# CITY OF ALBUQUERQUE

PLANNING DEPARTMENT – Development Review Services

October 2, 2015

**RE: Gutierrez Trucking Maintenance Facility  
3006 Todos Santos St. NW  
Grading & Drainage Plan  
Engineer's Stamp Date 8-20-2015 (File: G10D036)**

GRADING & DRAINAGE PLAN
Scale 1"=20'-0"

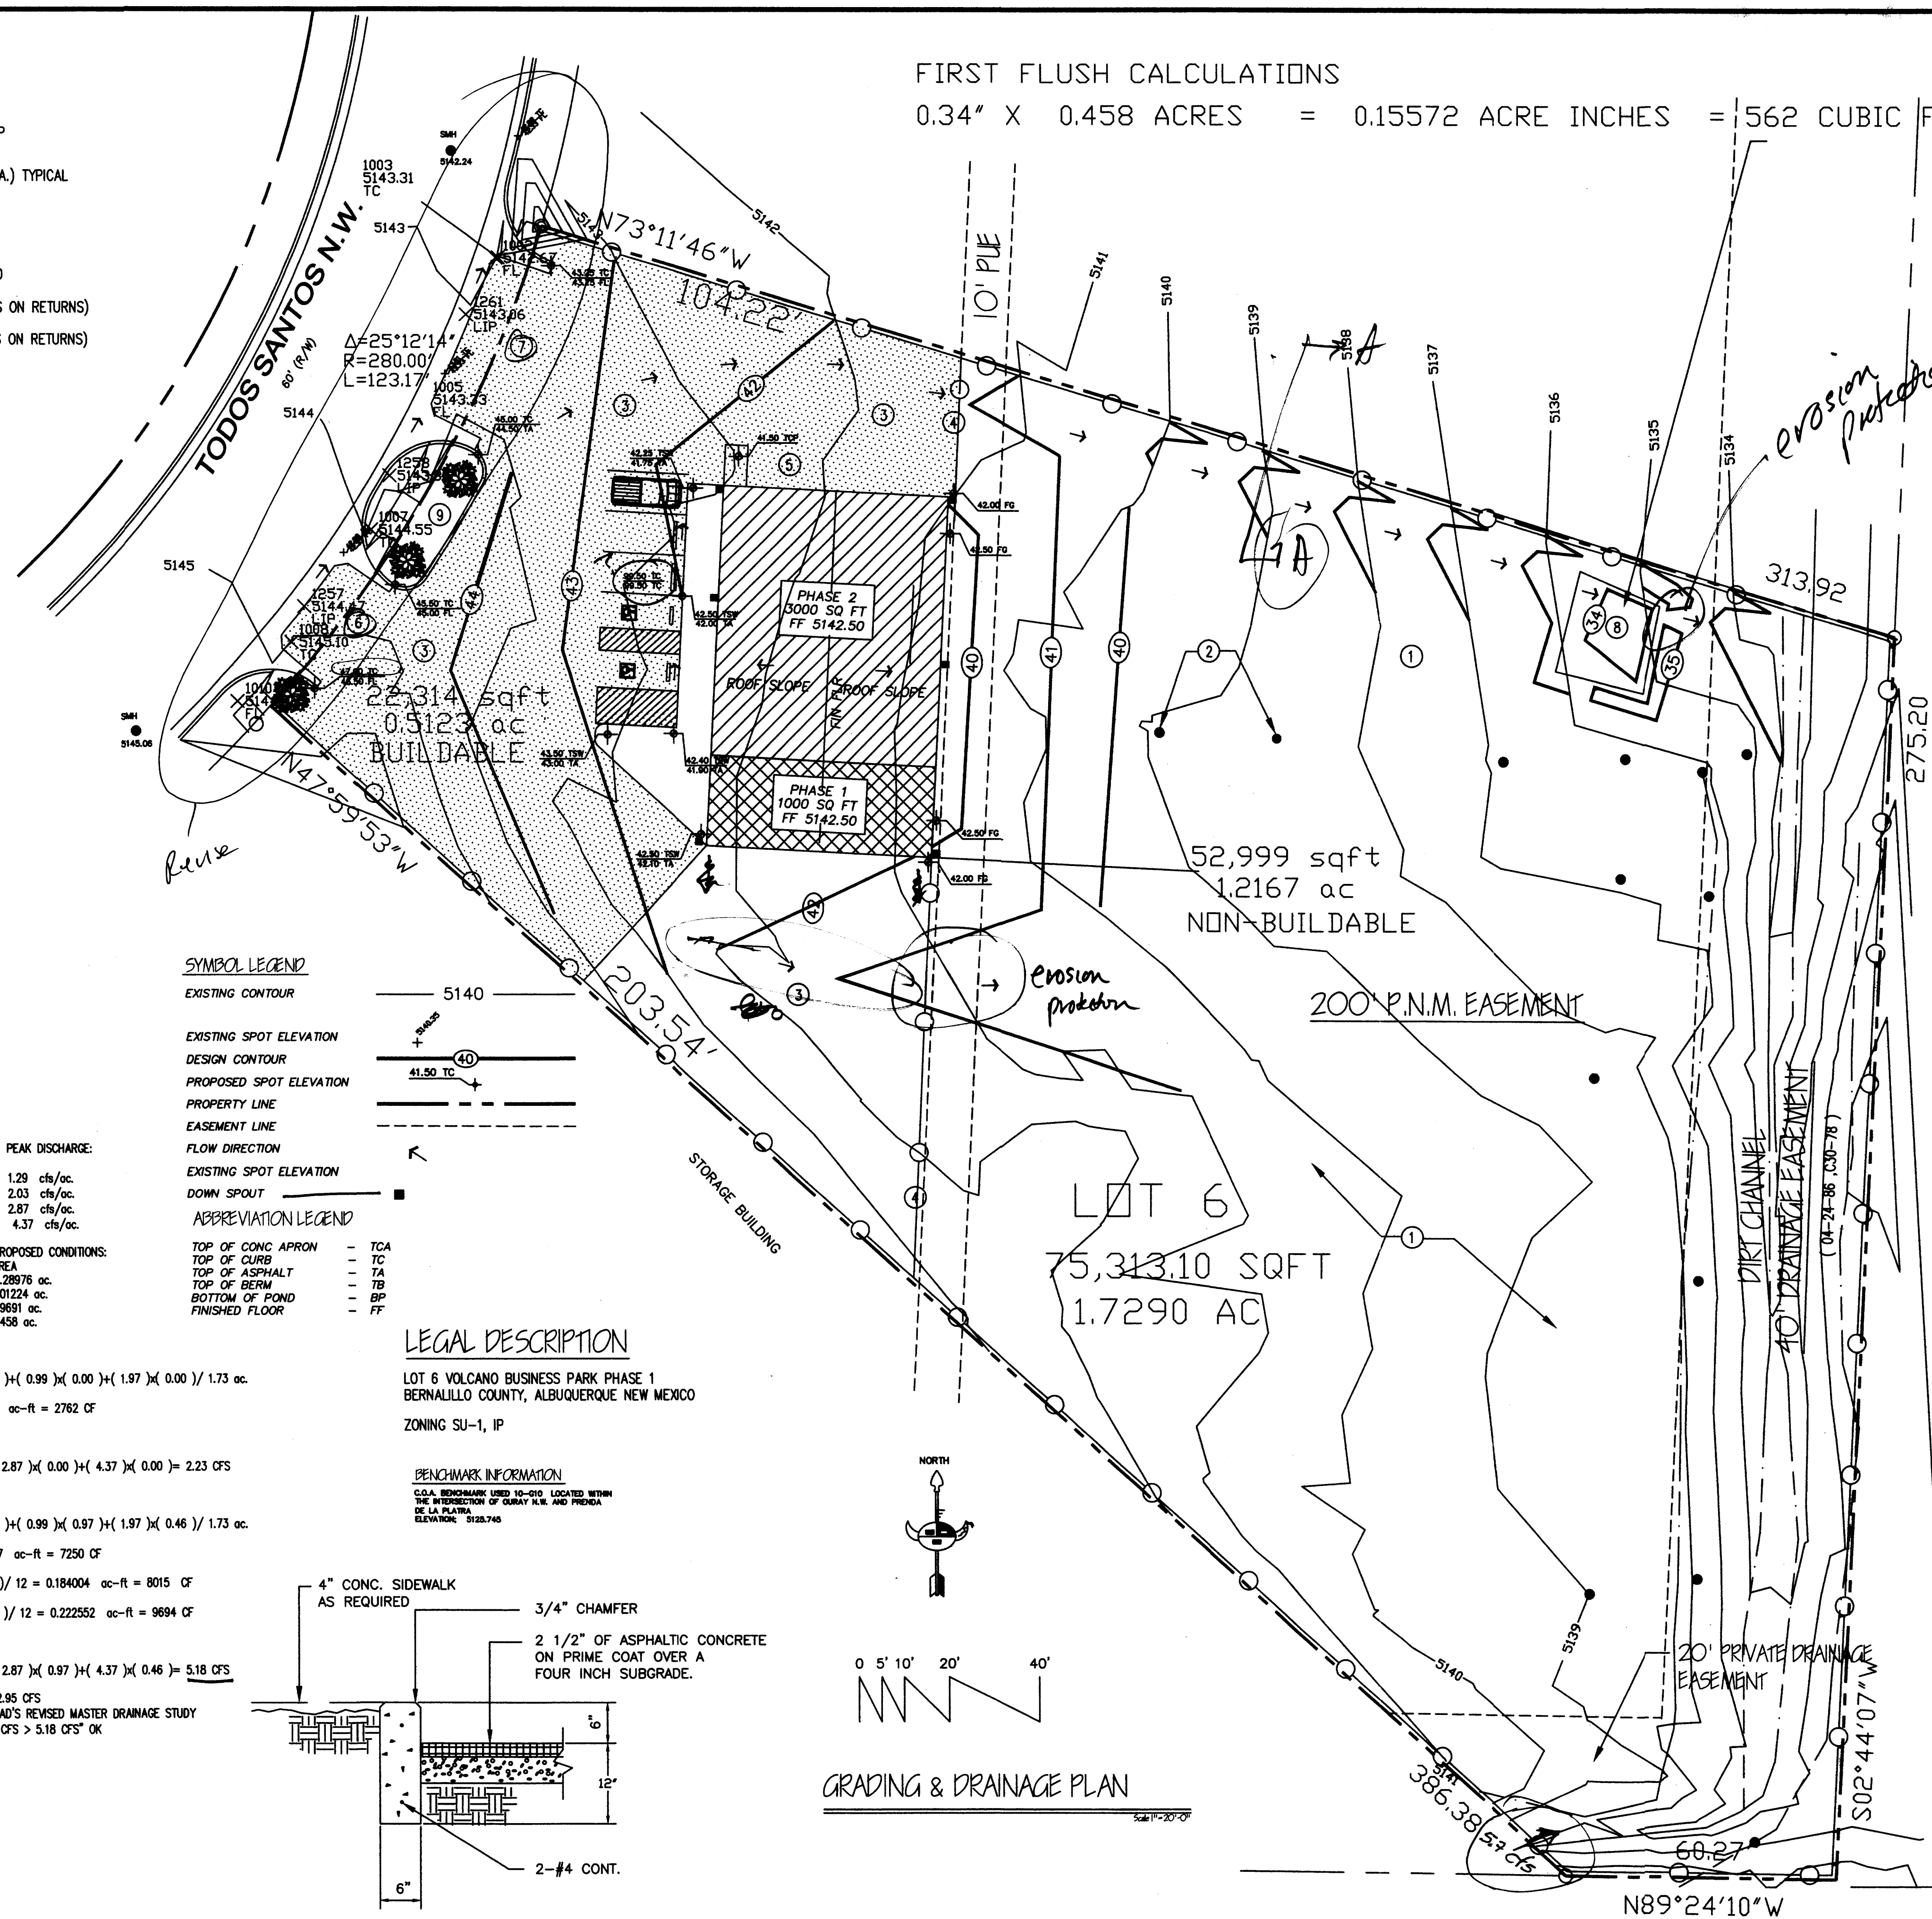
- 1) Since this project will not go thru the DRC process, the entrances must be adequately detailed per COA Std Detail 2420. Show existing flow line elevations, quarter point elevations, intersection of flowline elevations, etc. There is overlapping text and line work making the plan difficult to understand in this area. It may be necessary to provide a separate detail.
- 2) Water blocks are not evident. Please use a zigzag line to note waterblocks.
- 3) Provide a section of the swale to the pond and show erosion protection.
- 4) Provide erosion protection at the first flush pond, for both discharging and inflowing runoff.
- 5) Asphalt swale on south side of building discharges to gravel. Provide some means of erosion protection at discharge point.
